**KIRKLEES METROPOLITAN COUNCIL
INVESTMENT & REGENERATION SERVICE**

DELEGATED DECISION TO DETERMINE PLANNING APPLICATIONS

Reference No:	2025/62/91195/W
Site Address:	The Bungalow, 16, Kaye Lane, Linthwaite, Huddersfield, HD7 5RJ
Description:	Erection of first floor extension and raising of roof and eaves height
Recommending Officer:	Joshua Merriman

Officer Report – 2025/91195

Project Proposed extension and alterations.		
For Mr R Braund.		
Address 16 Kaye Lane Linthwaite. HD7 5RJ		
Title Proposed layouts and elevations.		
Job No. -----	Drawing number 04	Date Apr 2025

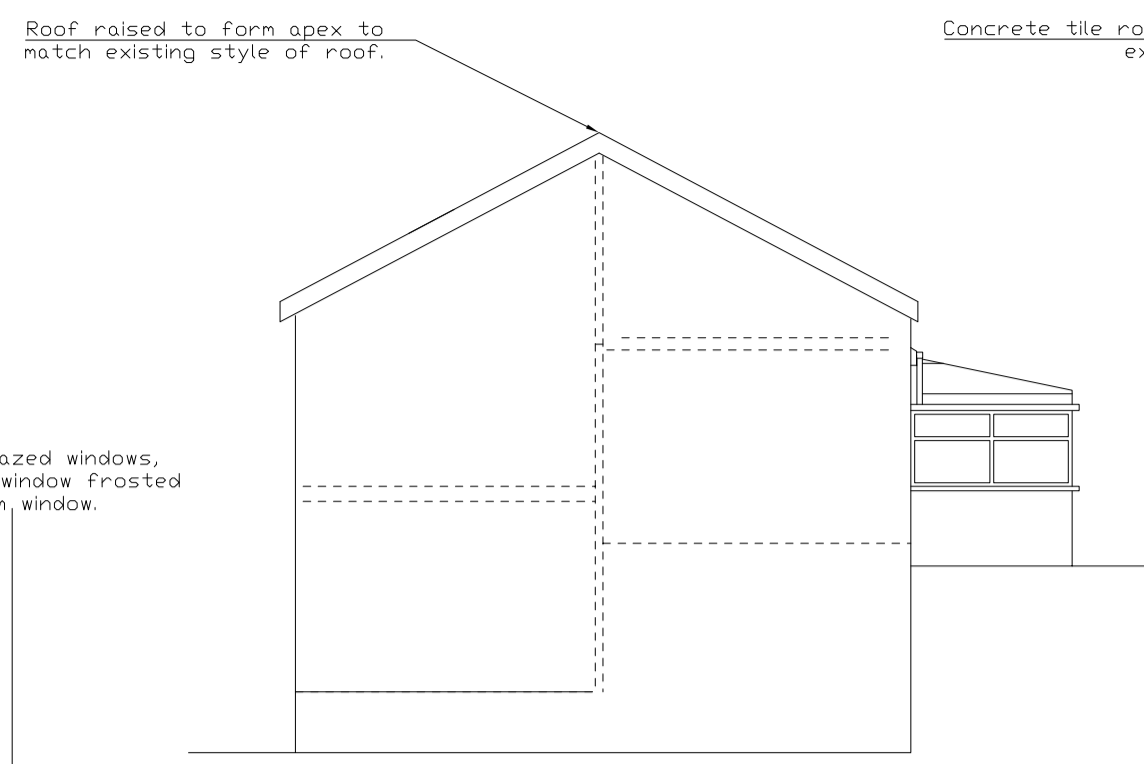
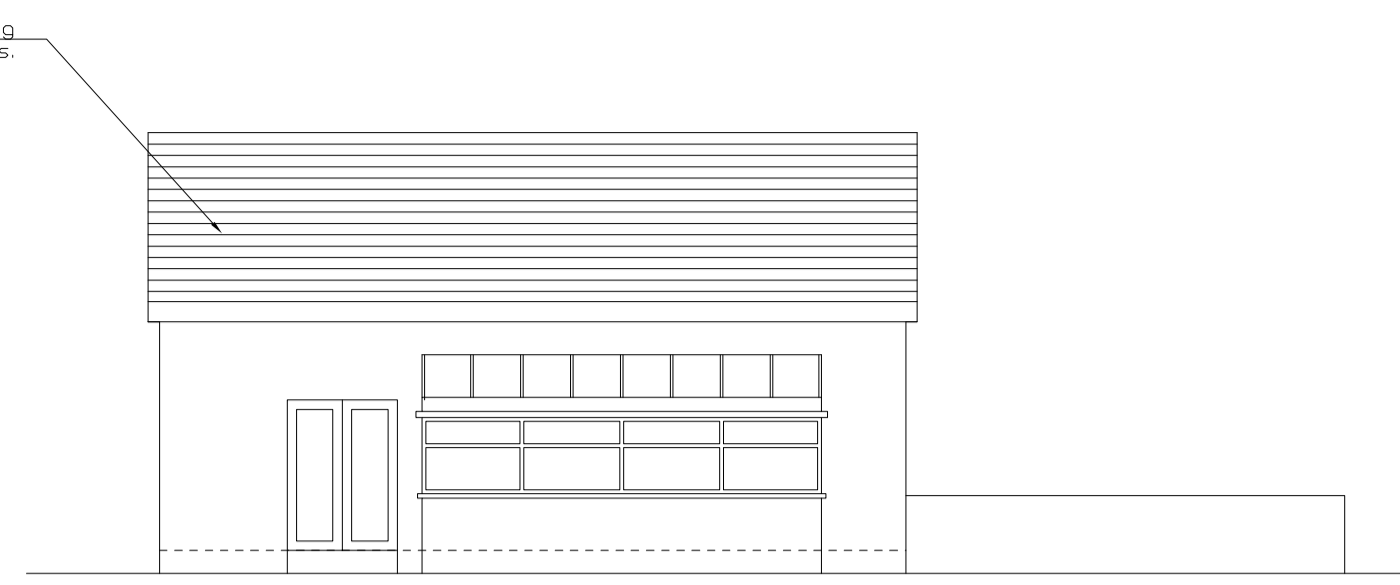
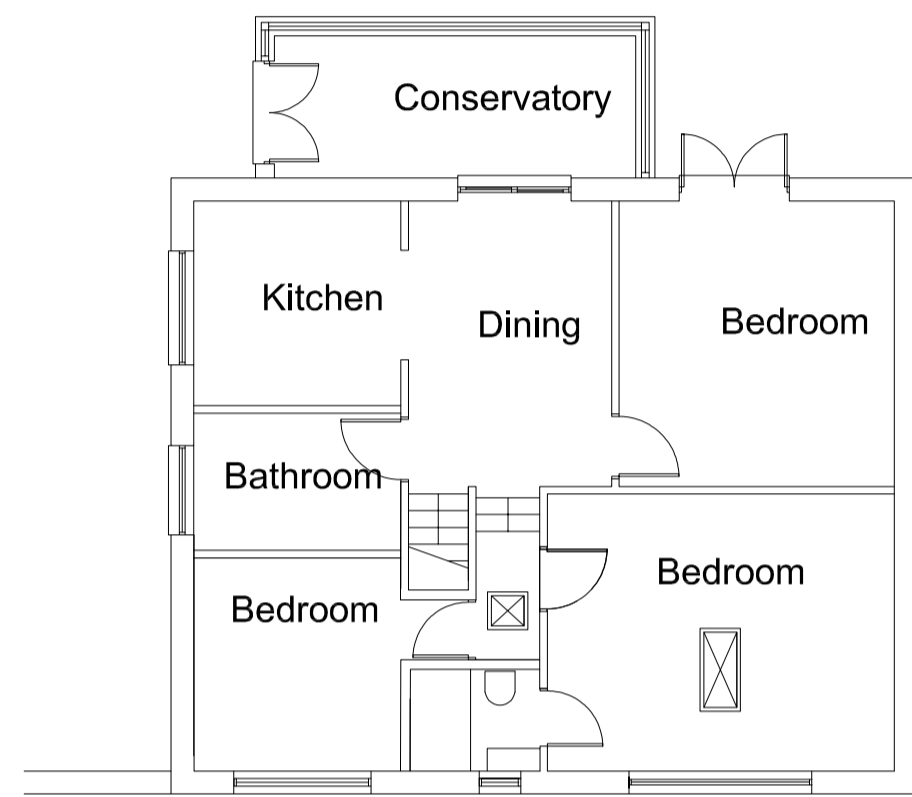
The case officer requested that consideration was given to the reduction in the scale of the originally proposed dormer, or the raising of the roof height at the property rather than the initially pitched dormer which was considered overpowering to the roof plane and street scene. Following this recommendation, the applicant submitted plans detailing the erection of a first floor extensions and raising of roof and eaves height which was considered acceptable.

It is considered that the proposal promotes good design by utilizing materials to match the existing building, furthermore, the addition of an extra floor in the building, that is currently a bungalow, is considered to have no significant impact on the street scene as the dwelling is neighboured by multiple two-storey properties.

Moreover, as there are no additional windows proposed in the side elevations of the dwelling, it is also considered that there will be no significant impact upon overlooking and the privacy of neighbours as properties to the North West and South East are an adequate distance.
